From: Sue Howell
Sent: 29 November 2017 12:20
To: Planning.Responses
Cc: Anita Gardner
Subject: RE: Planning Consultation on A/171/17/DOC

APPLICATION NO: A/171/17/DOC

Site Address: Herons Farm Dappers Lane Angmering

Works: condition imposed under planning permission A/184/15/PL relating to conditions 3-visibility splays, 4- details of screen walls and/or fences, 5-surface water drainage, 9-level survey, 10-landscape scheme, 11-schedule of materials & finishes & 13- location of swallows nests.

Proposed Cottages & Stables
 Herons Farm, Dappers Lane,
 Angmering
 Scale 1:200
 Drng no 459/08

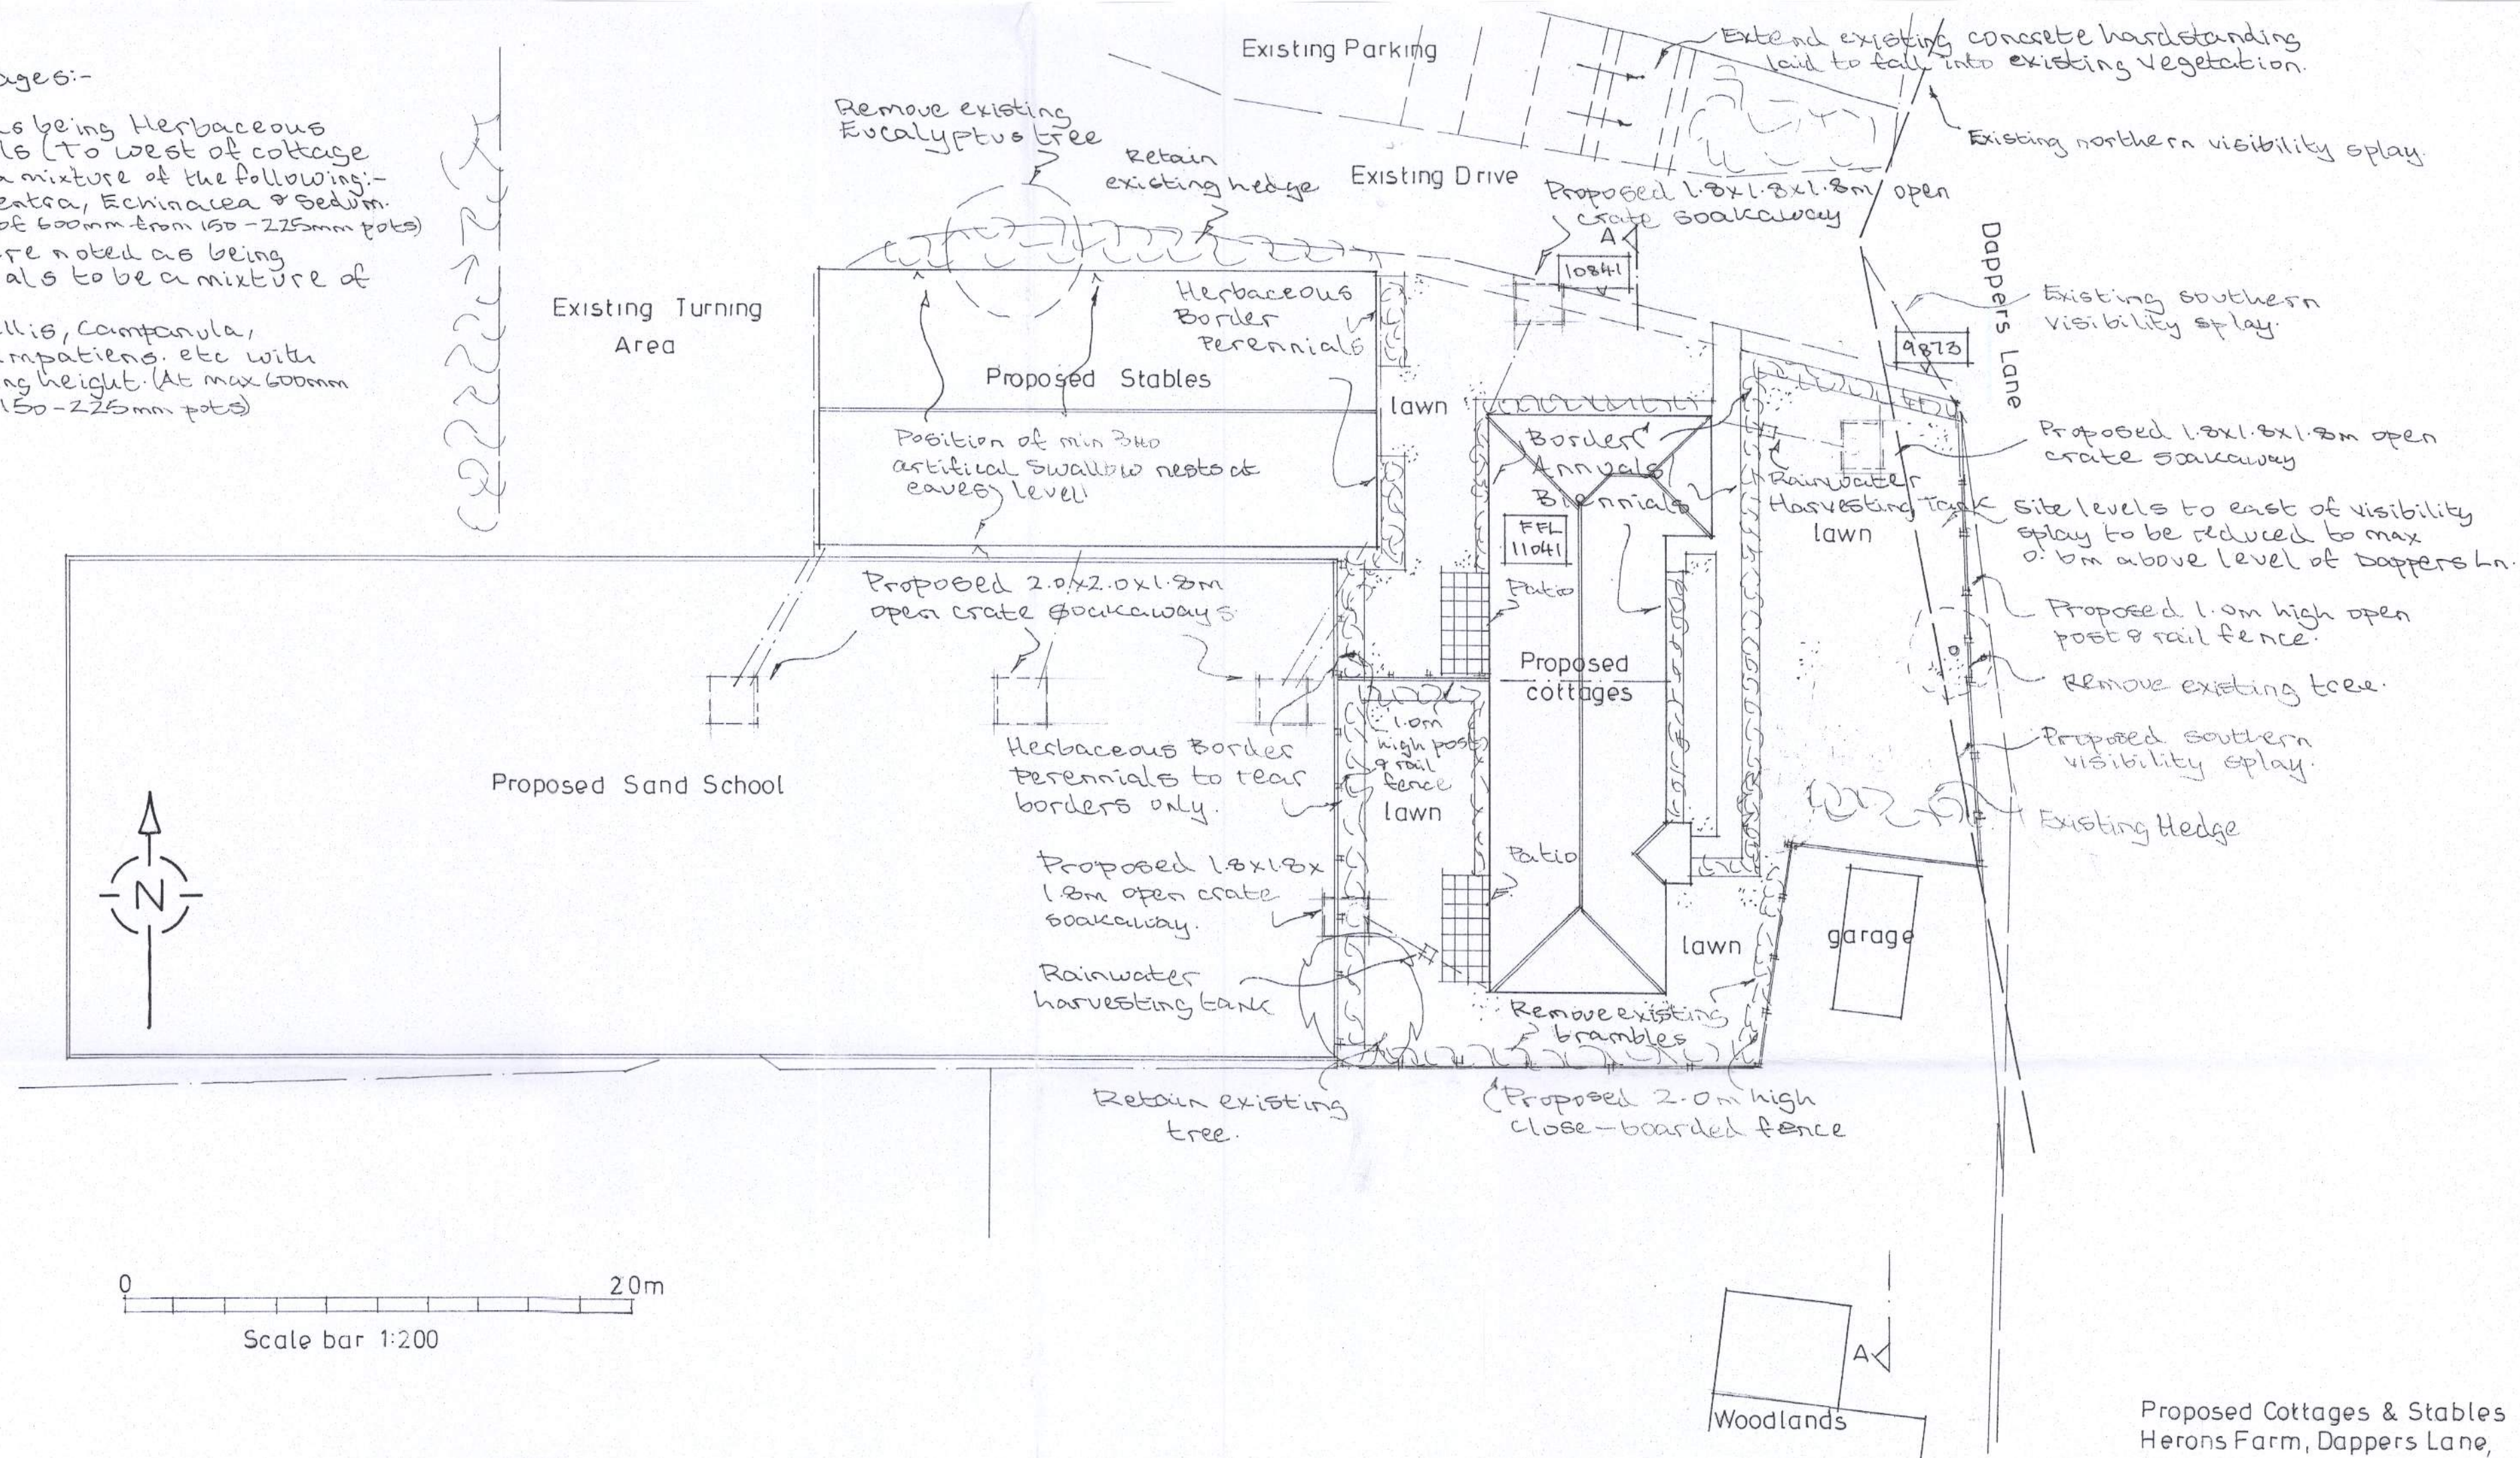
Further to submission of drawing No 459/08A, we can confirm that the information supplied being localised to the building and without requirement for mitigation or screen planting, does contain sufficient information in this case and being fitting for location we would **recommend the discharge of Condition 10 Landscaping reserved by condition imposed under planning approval A/184/15/PL on this application A/171/17/DOC.**
